Application by Lime Down Solar Park for an order granting development consent for the Lime Down Solar Project

Issue Specific Hearing 7 – Management Plans

Date: 17 September 2026

Action points arising

Title: **Figure 14-1-1: Noise Monitoring and Sensitive Receptor Locations**

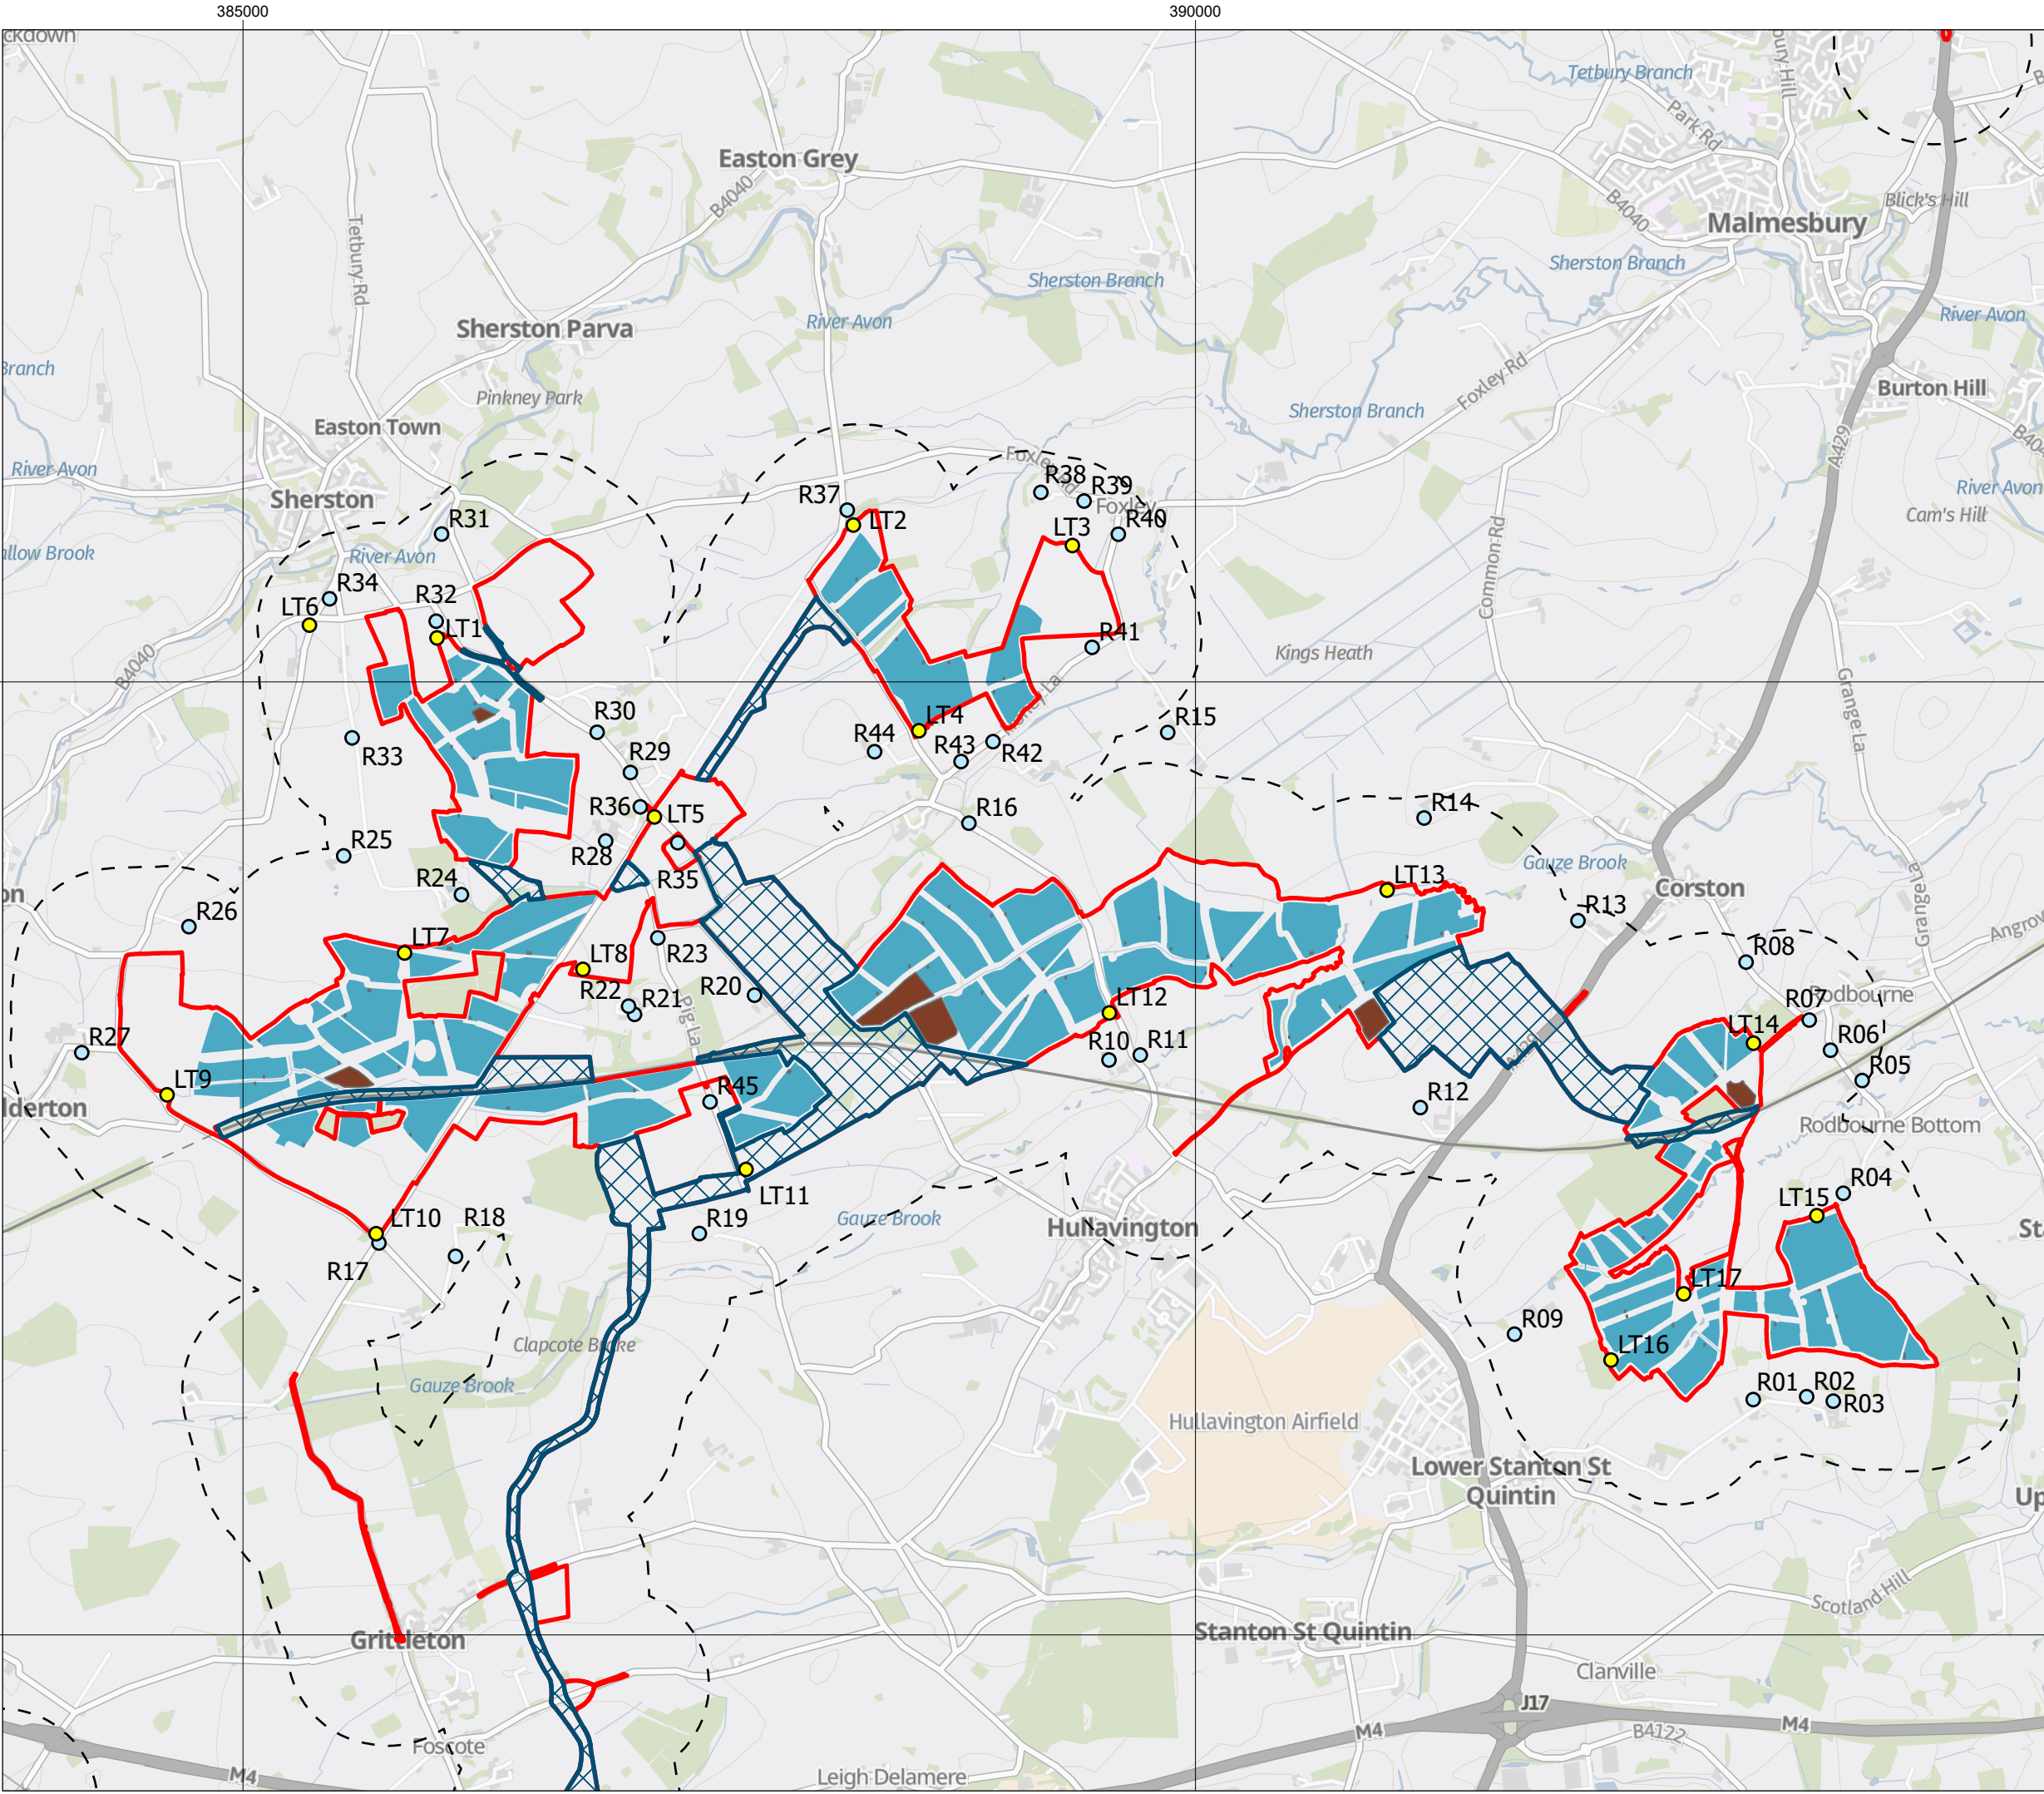
Outline Operational Environmental Management Plan			
23	Applicant	The commitments contained within ES Chapter 14, in relation to noise levels being reduced to below the LOAEL through the detailed design process, for receptors R12, R22, R25, R31 and R34 to be transposed in to the oOEMP. Similarly the commitment to installing silencers to reduce daytime noise to receptors R24, R41, R42 and R43 to be transposed in to the oOEMP.	D7
24	Applicant	The sensitive lightning strategy, as detailed in the oOEMP, to be aligned with wording used in other sections and relevant management plans.	D7
25	Applicant	To include additional wording in the oOEMP to clarify the mitigation hierarchy for badgers, so leaving badger setts in their current location takes priority over other options with licensing being the last resort.	D7
26	Applicant	To update the oLEMP to specify that the detailed LEMP to contain further information on the suitable type and condition of skylark habitat, how this will be maintained and potential triggers at which point further steps for mitigation need to be taken to improve the uptake of habitat. The wording regarding the	D7

Drawing file: published-documents / EN010168-002331-6.2 ES Volume 2 Figure 13-11 Construction Access Locations Solar PV Sites (Rev 2).pdf

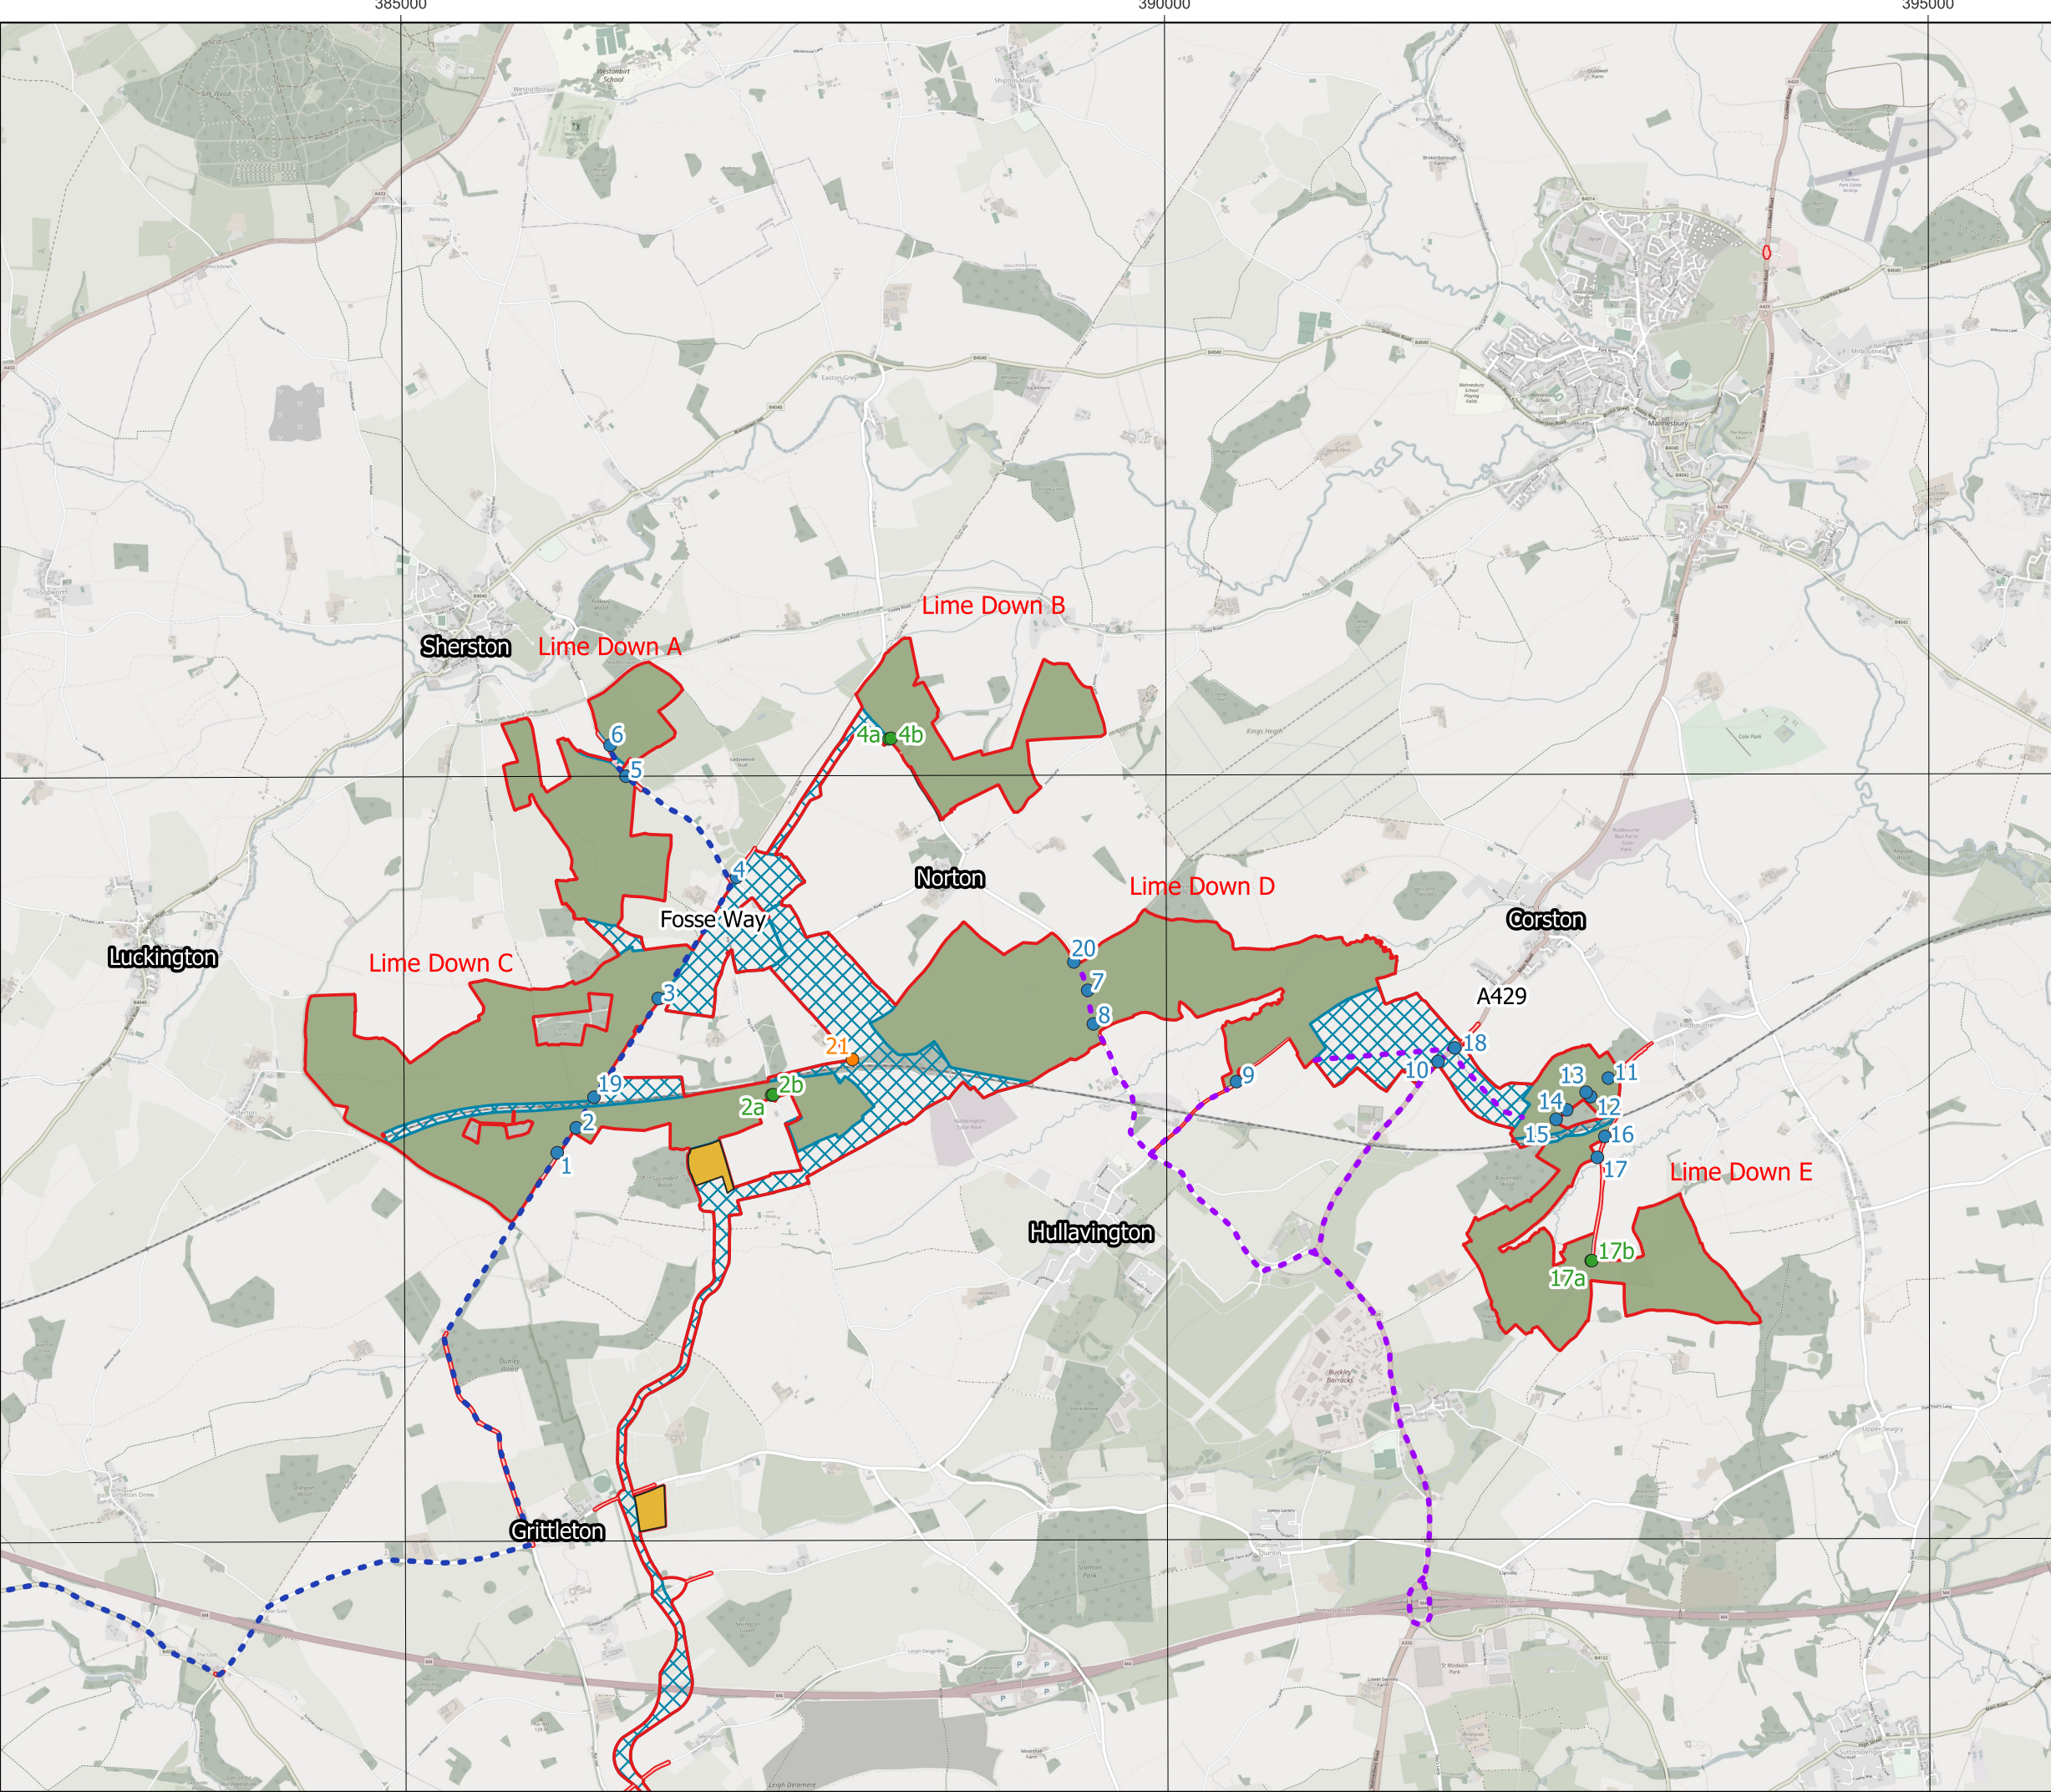
6	Applicant	To provide further information on the existing access points that will be used for PPW works and confirmation that no highway improvement works are required to facilitate use of those accesses.	D7
7	Applicant	To provide numbers of HGVs anticipated during the PPW phase to WC and SLD.	D7
8	Applicant	To update the pre-condition survey methodology to the version as detailed in the latest oCTMP.	D7
9	Applicant	To update table 3-12, along with other references to dealing with complaints in various management plans, to include a procedure which requires evidence on how complaints will be logged, responded to and acted upon rather than just received.	D7
10	Applicant	To provide additional wording in table 3-3 to require submission of ecological survey results to WC and consideration of proposed mitigation to be agreed with WC prior to any potential tree removal or site clearance.	D7
11	Applicant	To amend the PPW environmental management plan, such that no reference is made to outline documents, and it remains as a stand-alone document.	D7
